Planning and Urban Development Department

Subject: B7 Design Review – 20 Marginal Way

Written by: Caitlin Cameron, Urban Designer

Date of Review: Wednesday, July 8, 2015

AE202

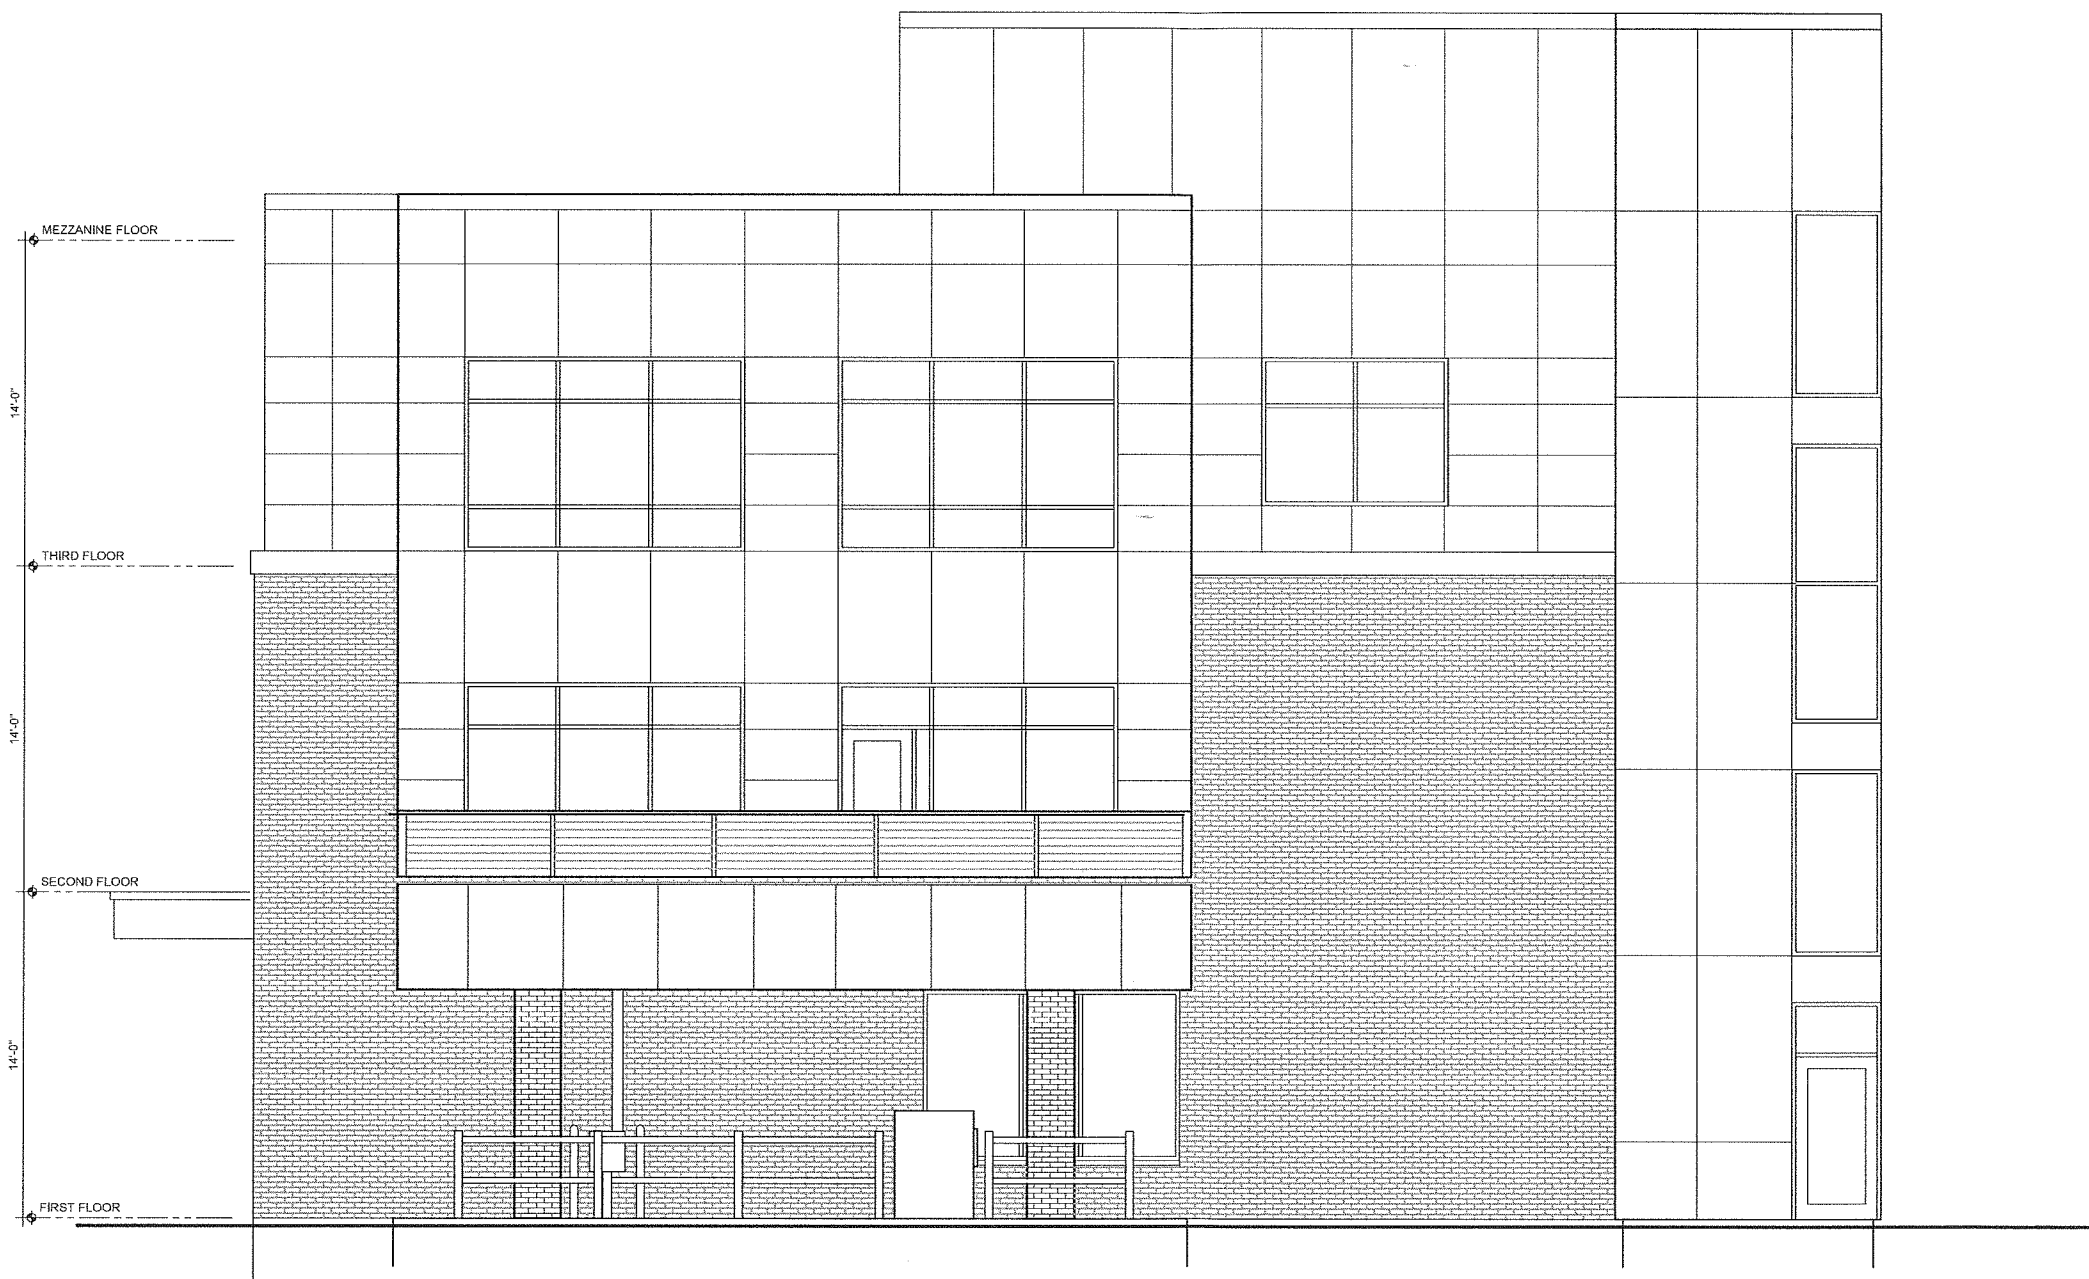
- **Proposed glass has a VLT of .56 which is lower than the allowed .7. A sample is required** before staff can assess whether the transparency is adequate.
- **Spandrel glass (opaque) is proposed** for the upper portion of the ground floor storefront which is **not allowed by the Standard. See comments below.**

- **Proposed transparency does not meet the Standard.**
- **Spandrel glass (opaque) is proposed** for the upper portion of the ground floor storefront **which is not allowed by the Standard. Staff does not support the use of spandrel glass in this project. Staff recommends that the ground floor windows be reduced in height** (and the canopy subsequently lowered) and the area where spandrel glass is proposed be eliminated. Reducing the amount of glazing will also reduce the solar gain in the façade.

- **Proposed glass has a VLT of .56 which is lower than the allowed .7. A sample is required** before staff can assess whether the transparency is adequate.
- **Proposed glass has a green tint** which is not allowed by the Standard. **Glazing should look clear. A sample is required** before staff can assess whether the color is adequate.
- **Spandrel glass (opaque) is proposed** for the upper portion of the ground floor storefront which is **not allowed by the Standard. See comments above.**

- **Applicant is proposing a signage master plan that does not meet the Design Standards and will require waivers for the following:**
 - **Illuminated plastic sign letters** - Given the precedent of waivers granted in B-7 for plastic illuminated letters, **staff supports the waiver request** for allowing this sign design.

- **Number of upper level signs** - The guidelines limit the number of upper story signs to two (2) and the applicant is requesting three (3). **Staff defers to the Planning Board** on the appropriateness of additional signs. If the Planning Board does not support the waiver request, staff recommends the two upper level signs on the building's short faces which will be visible to vehicular traffic.

- **Number of pedestrian level signs** – The guidelines limit the number of pedestrian level signs to one (1) and the applicant is requesting two (2). **Staff defers to the Planning Board** on the appropriateness of additional signs. If the Planning Board does not support the waiver request, staff recommends the pedestrian level sign facing Marginal Way.
